Planning Application Ref: LU/366/17/T

Location : Wilbury House, 45 Beach Road, Littlehampton

Description of works: Reduce lateral spread by 1m to 2m on 1 No Scots Pine

### 7. Identification Of Tree(s) And Description Of Works

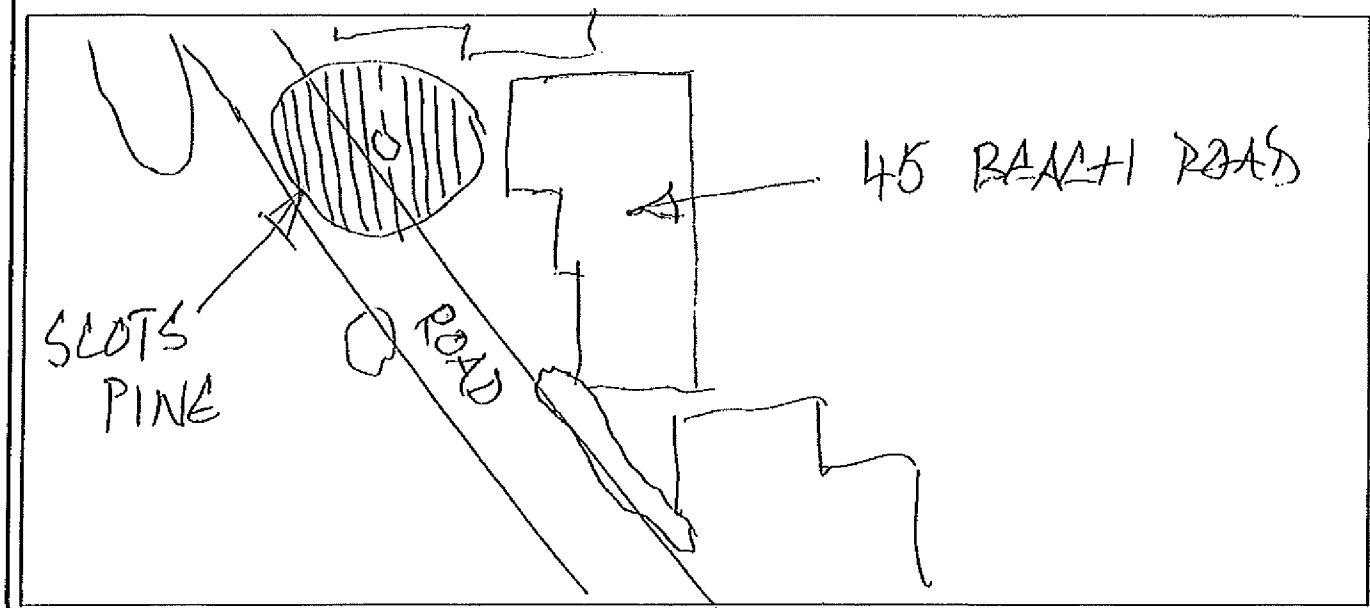
- A mature tree that is sound and healthy and makes a significant impact in the landscape.
- The low branching habit is causing problems and needs to be addressed.
- The height is currently not an issue and I note that no works have been applied for in this respect.

- The request to reduce the lateral spread by as much as 2m is excessive and could be harmful not only to the visual appearance of this tree in the landscape but will also be contrary to BS3998:2010 recommendations.
- It is not necessary to prune this tree this heavily to resolve the issues whilst leaving a tree of good shape and form.

- I recommend **APPROVAL but only** for the pruning of this tree as follows:-
- Shorten the lateral spread in a balanced manner up to half the height of the tree (7.5m from ground) by a maximum of 1.5m all round.
- Prune the tree from 7.5m above ground up to the trees full height of 15m by shorten the lateral spread by a maximum of 1m all round.
- ***There is to be NO reduction in the height of the tree.***

- *Where branches are to be shortened back the final cuts are to be made at the correct angle shown in BS3998:2010 and adjacent to a live bud or lateral.*
